16. Canada Road,
Arundel.

As the owner of No 16. Canada Rd I
am writing to oppose the preplanning
application for 12 - 14 Canada Rd. (AB115/14/0107)

Drg Title: SITE PLAN		Drg No: 14/1950/S01
Client:	Location:	Rev: A
MR SCODFREY	12-14 CANADA ROAD	Scale: 1:200 (A3)
	ARUNDEL	Drawn by: JSW

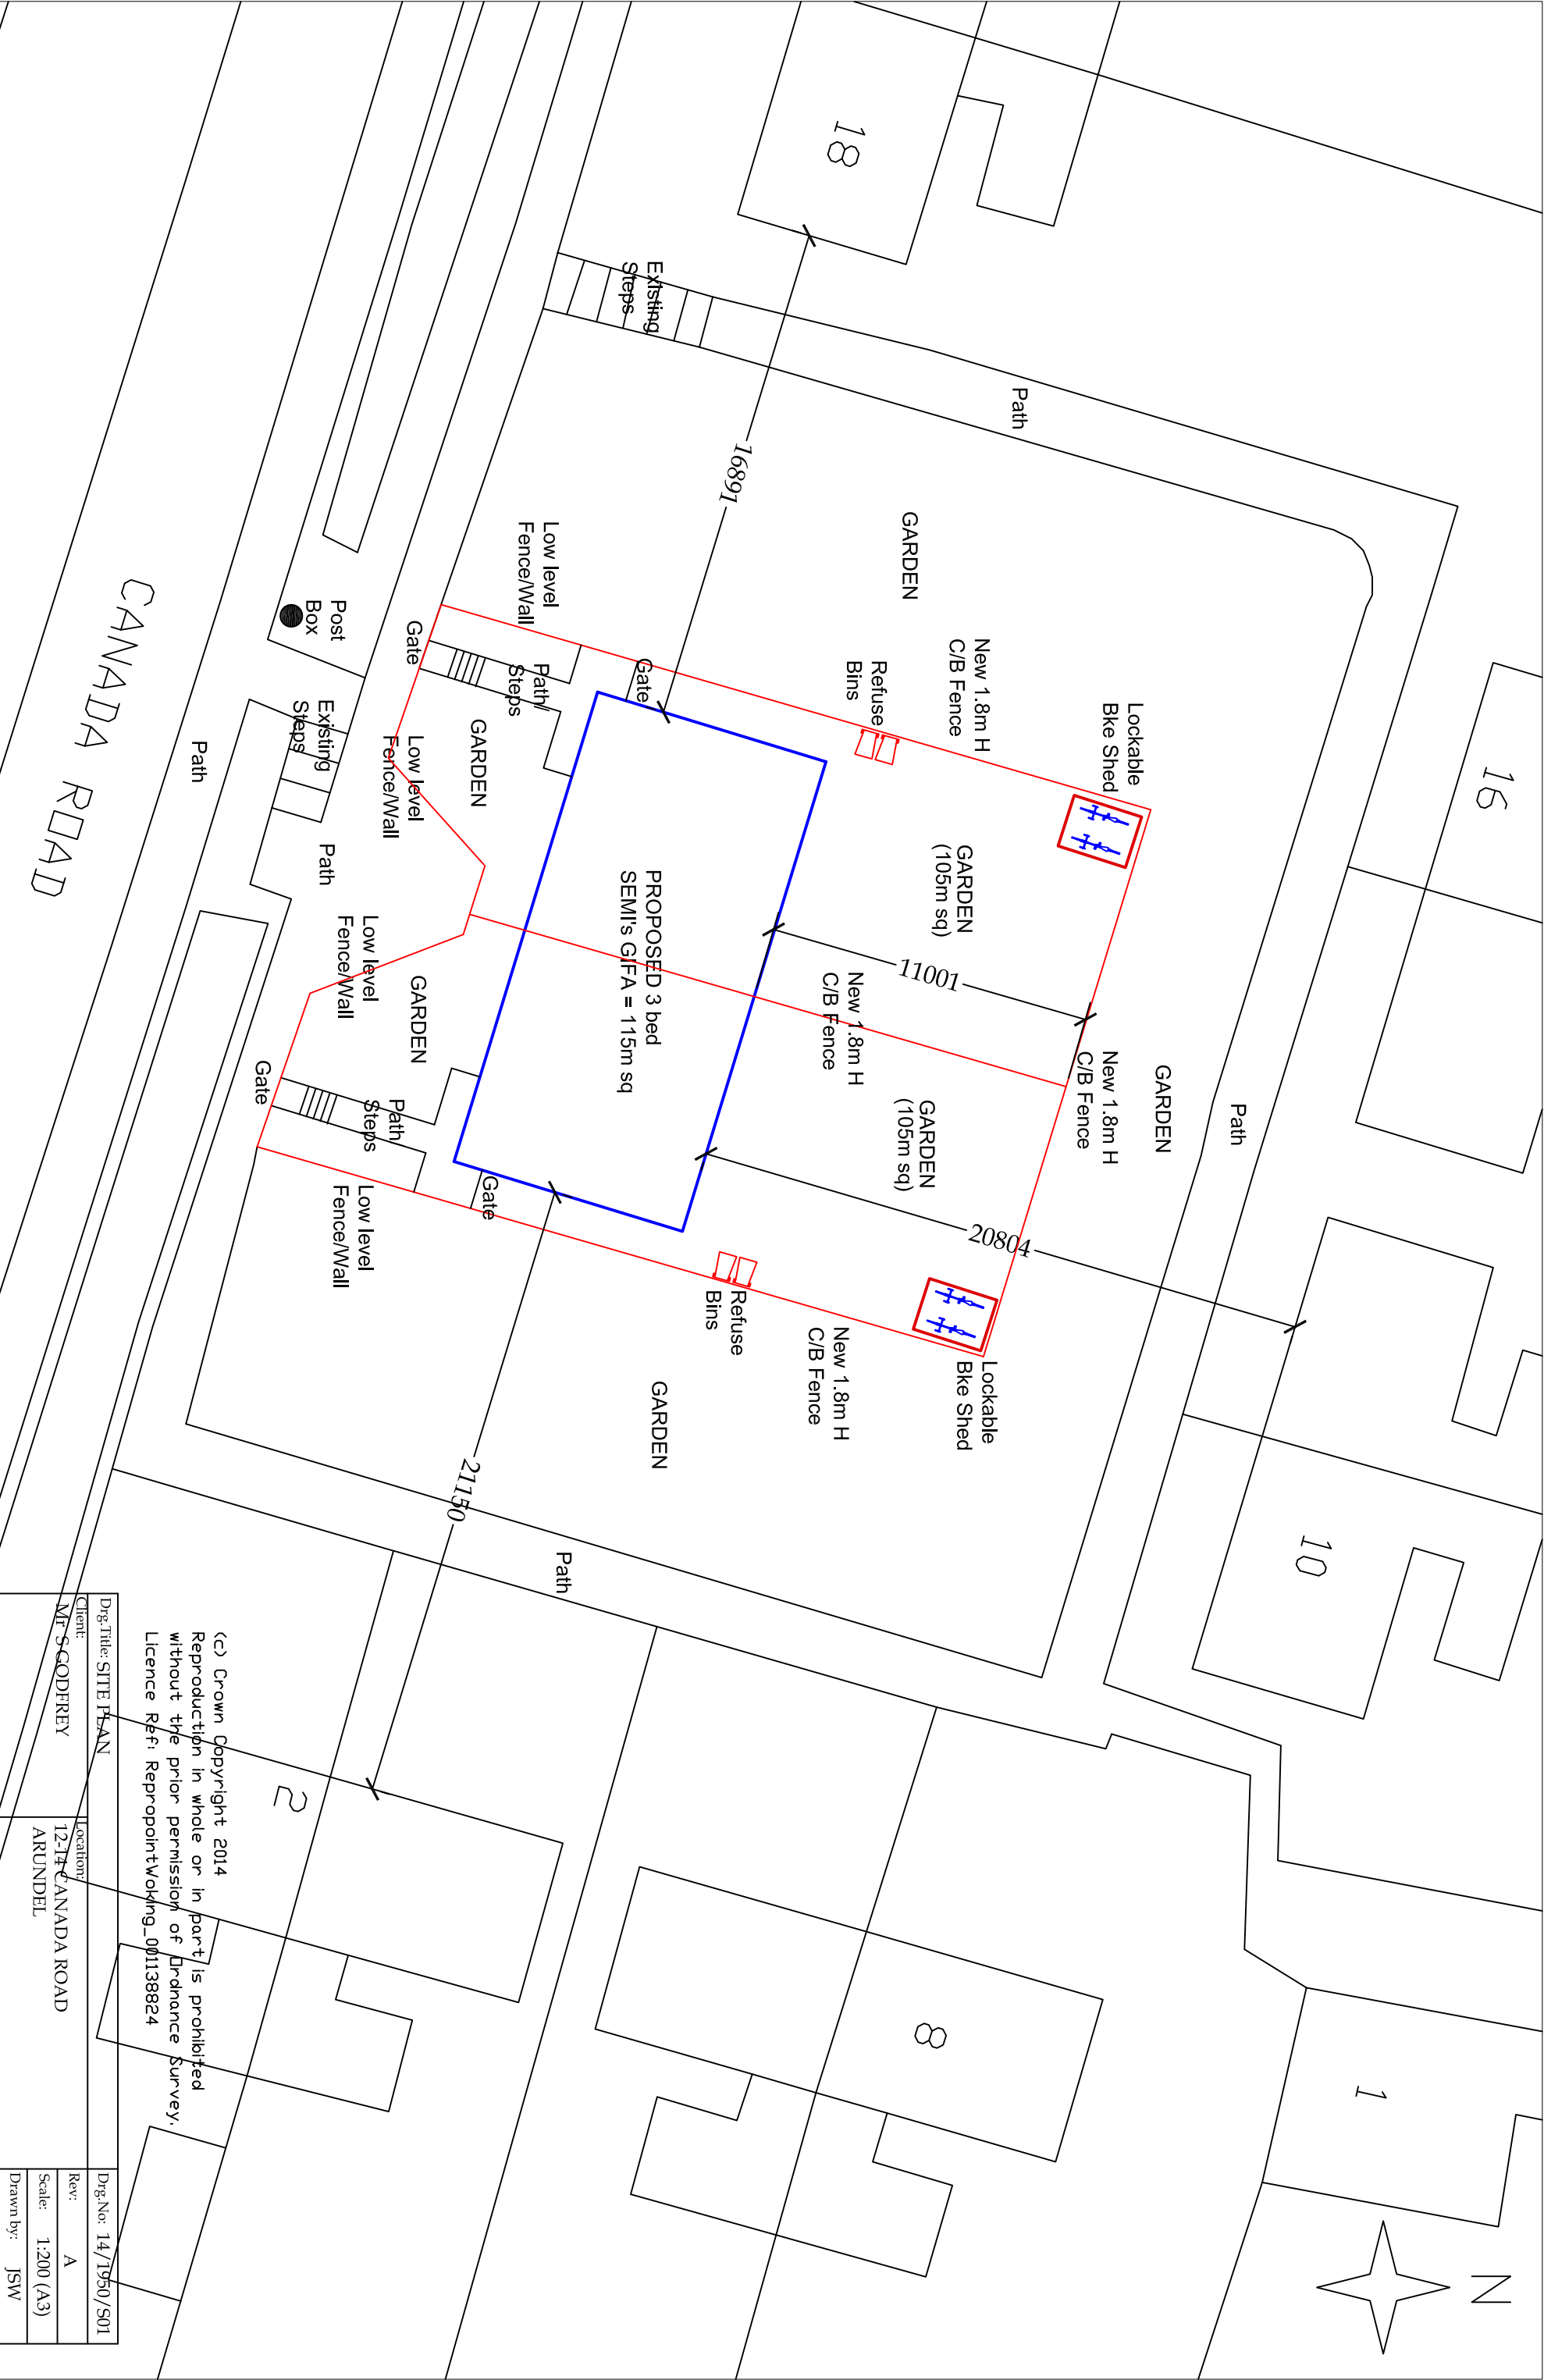
If houses are allowed to be built, we
will be looking directly out onto the rear
of the new properties and we would feel
hemmed in, as we are in the corner plot,

especially as a high fence is proposed approximately 5 meters from my property.

In addition the new properties would be lower than ours and we would be able to look into their windows and they would be able to see into our dining room and bedroom from their first floor.

We note there are no parking spaces being proposed in the plan and are worried that this will cause more congestion in an area where there are already parking problems. My husband and I are elderly and often find it difficult to park near the steps. The new properties would mean an addition to the number of cars already competing for limited space. We cannot use the area they call "offroad" as this is uneven and muddy, it is also park land, not car parking as stated.

Reading our deeds under Clause 3 (7th Sept: 1981), there are covenants and from this we believe we have access across the path in between the front of the properties 12 & 14 and believe they may not be able to build across the path and disputes over access may become a problem if the building went ahead.
